Cowfold Rampion Responses to Local Impact Reports Deadline 2

Comments on REP1-044 Horsham District Council Local Impact Reports:

Great Crested Newt environmental DNA survey report 2021-2023

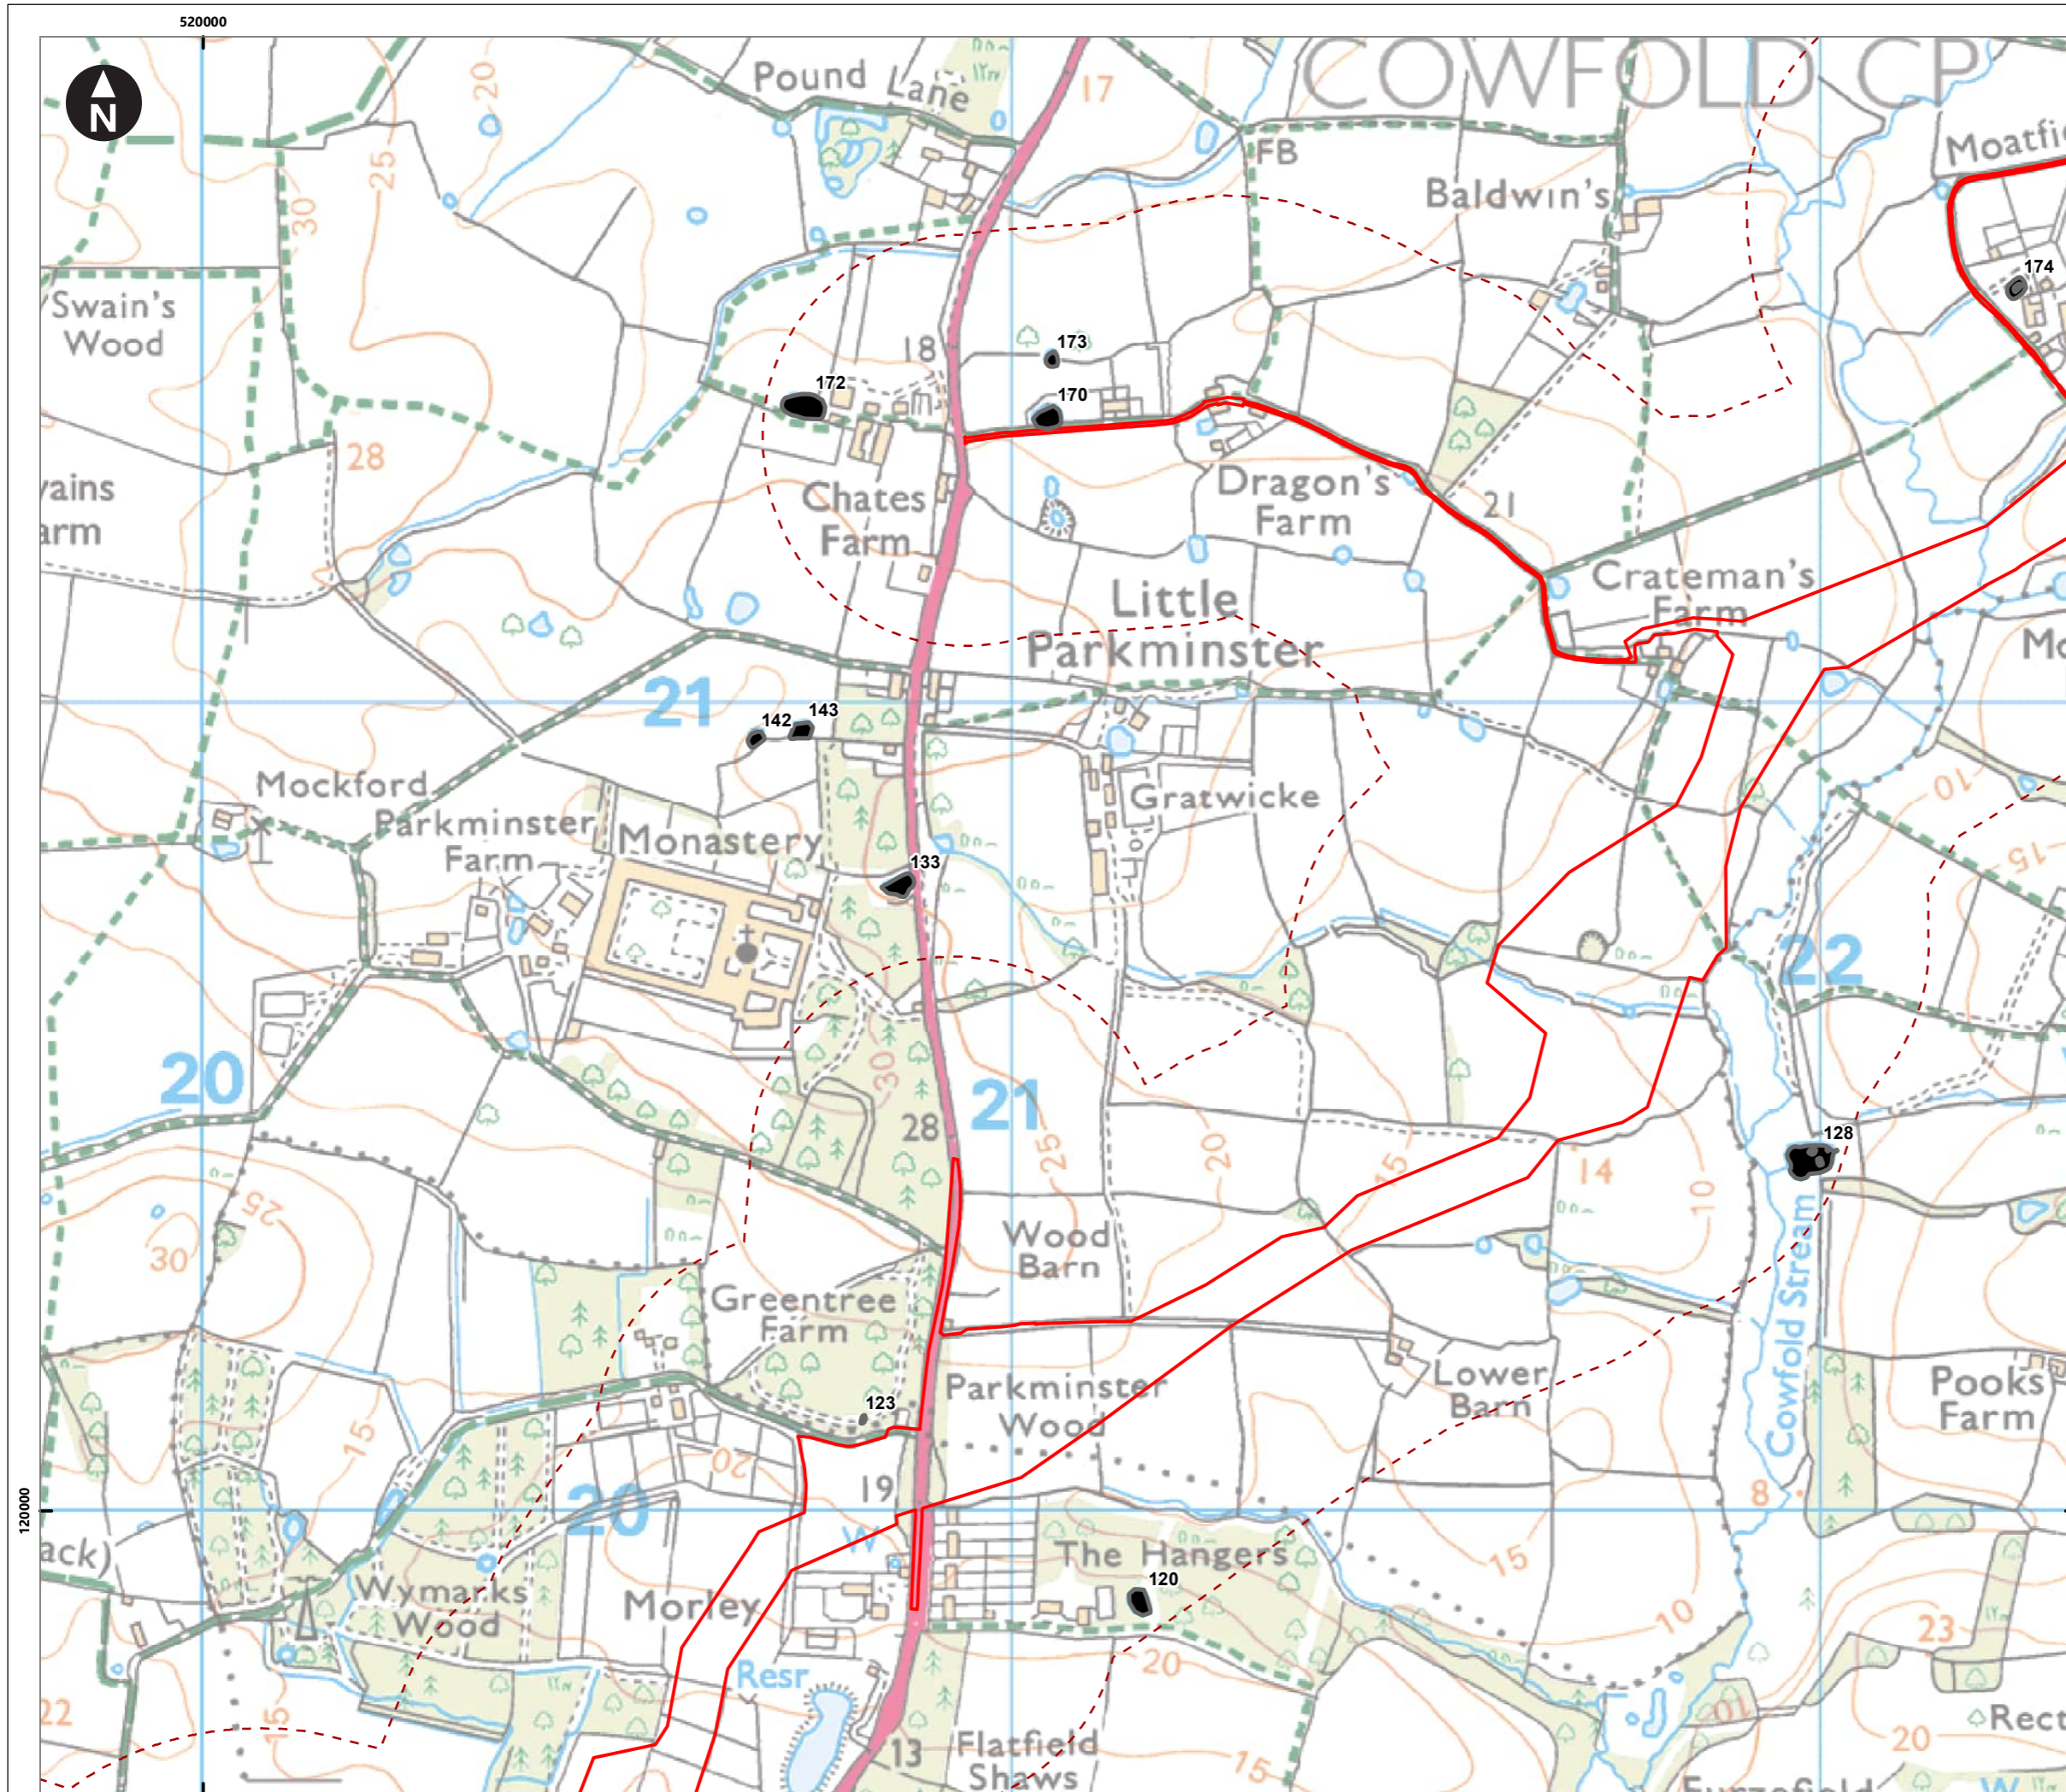
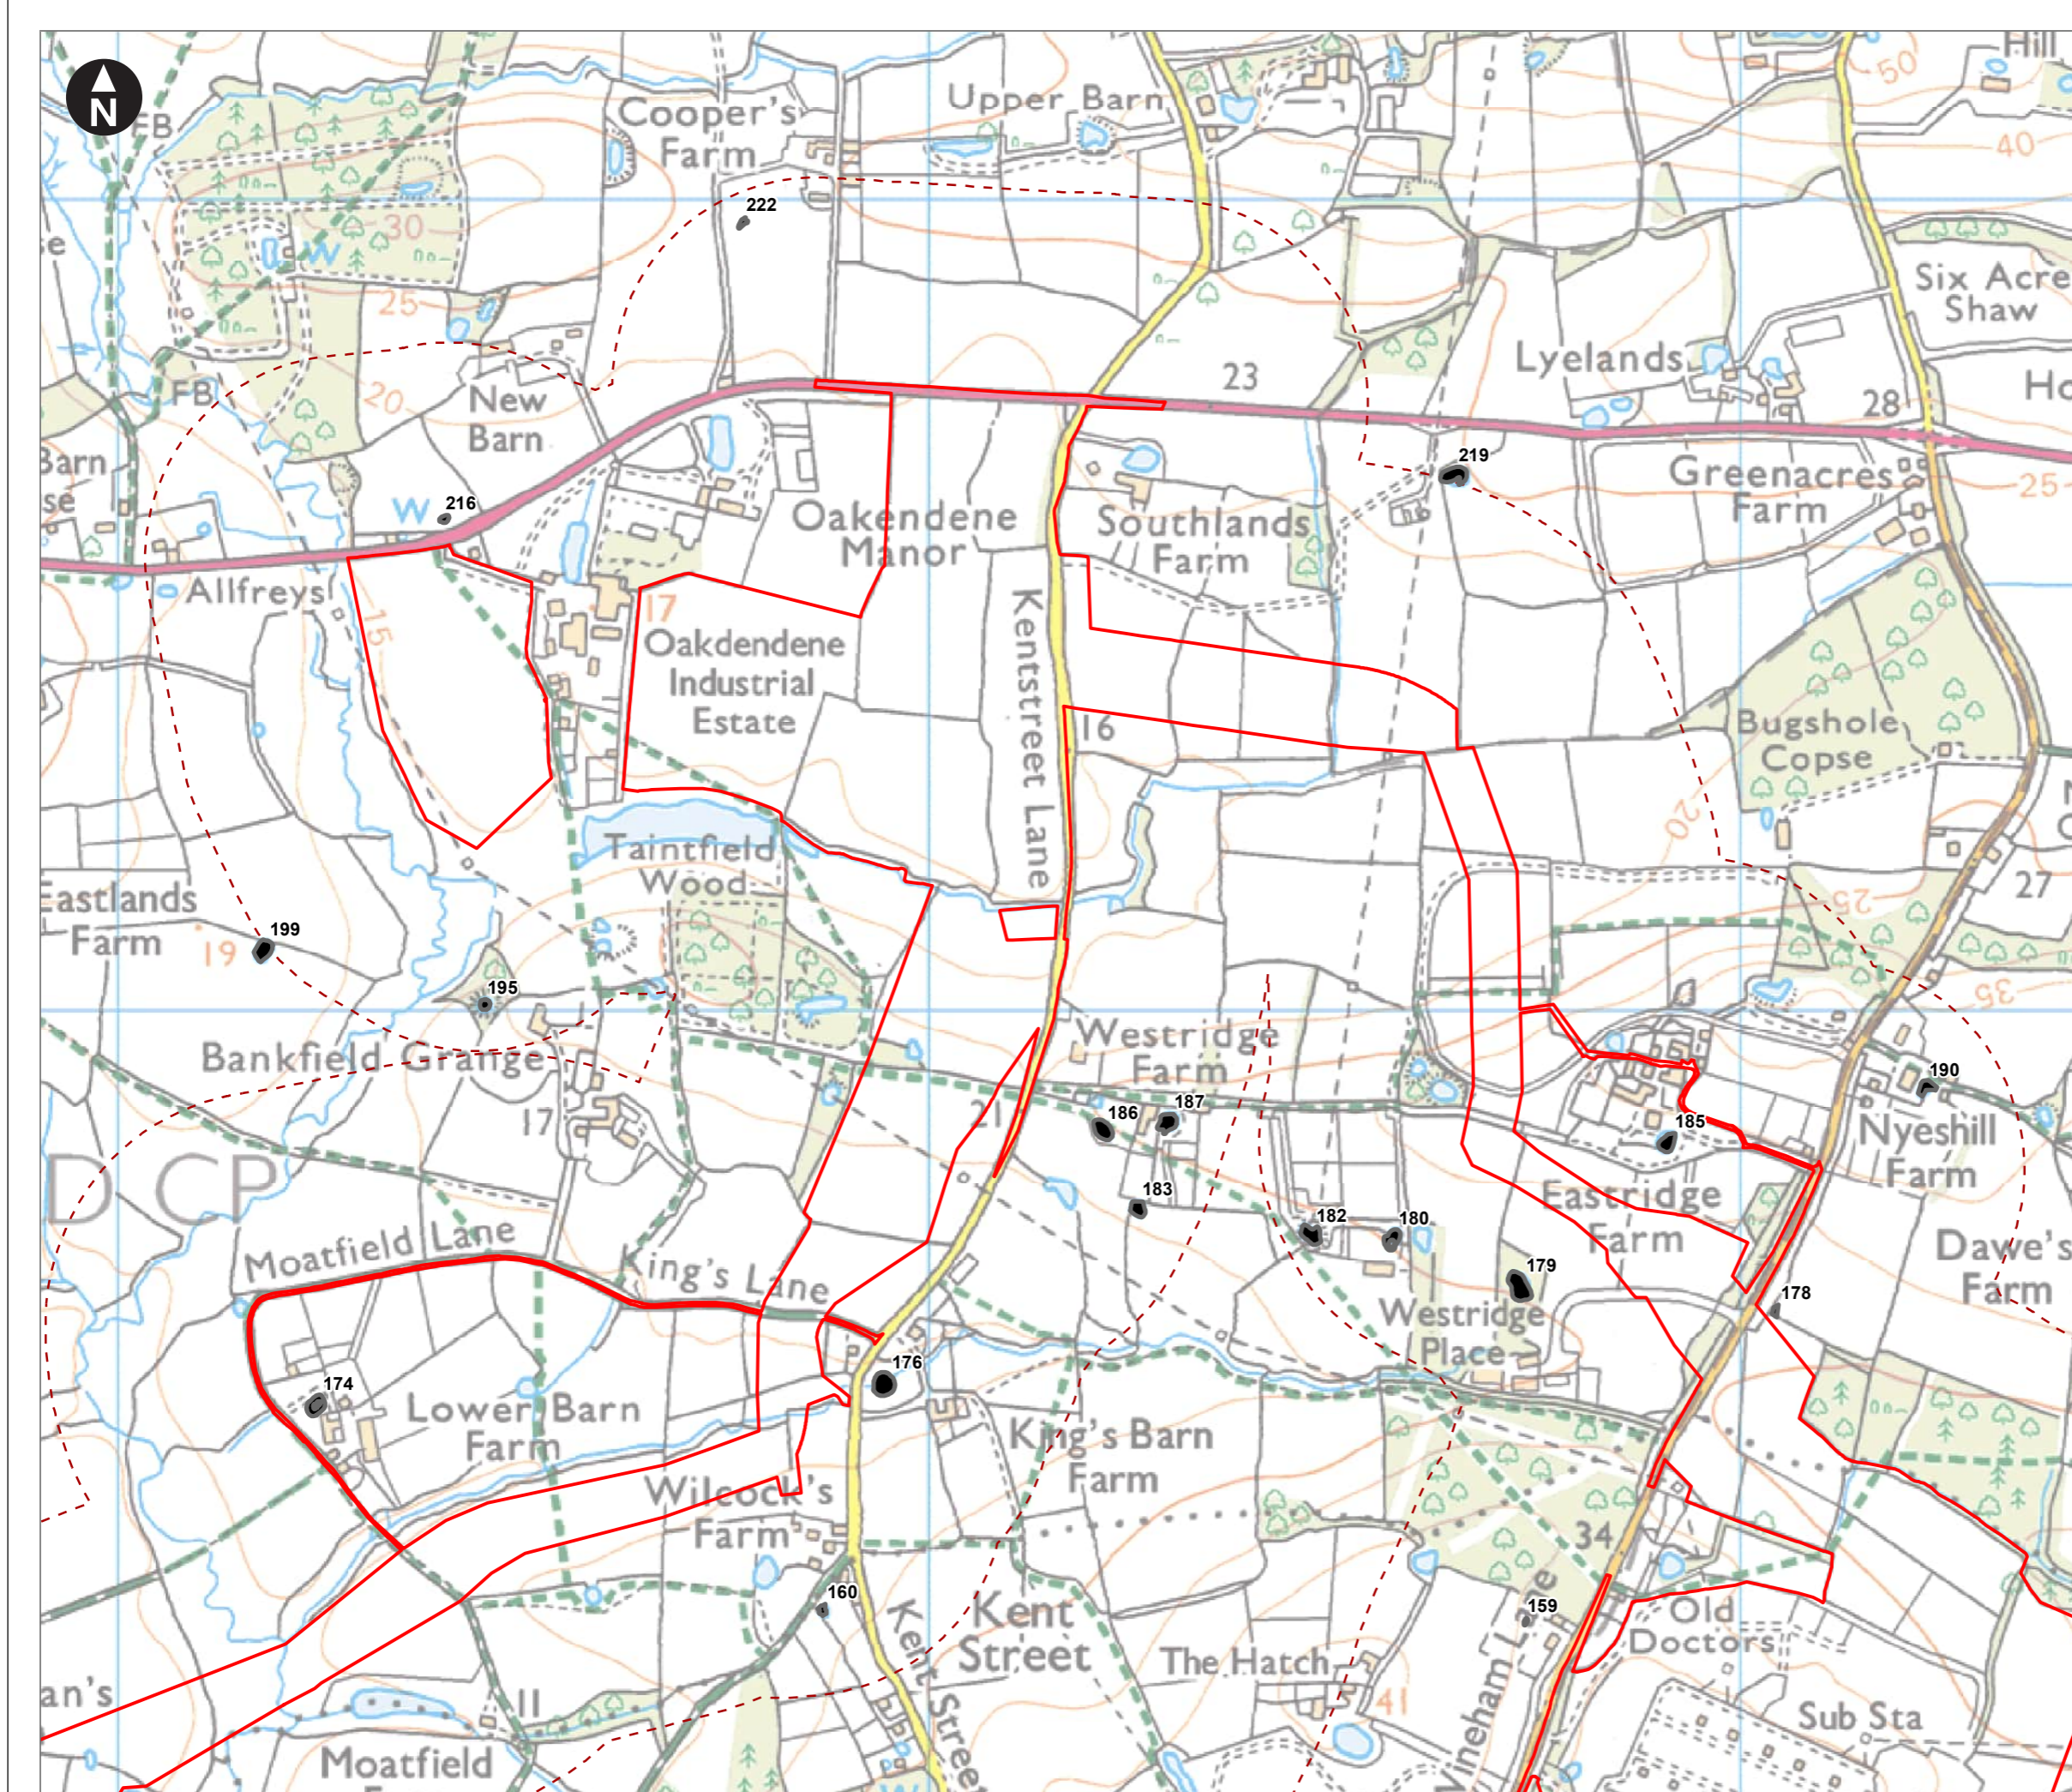
3.1) CowfoldvRampion endorses Horsham DC’s concerns but would like to add that the sites chosen for meadowland survey also do not reflect the most valuable meadowlands. The newt ponds and survey dates are already available; they show a high proportion of ponds in this area were either not surveyed as they were ‘inaccessible’, or were surveyed outside prime months, or DNA was degraded.
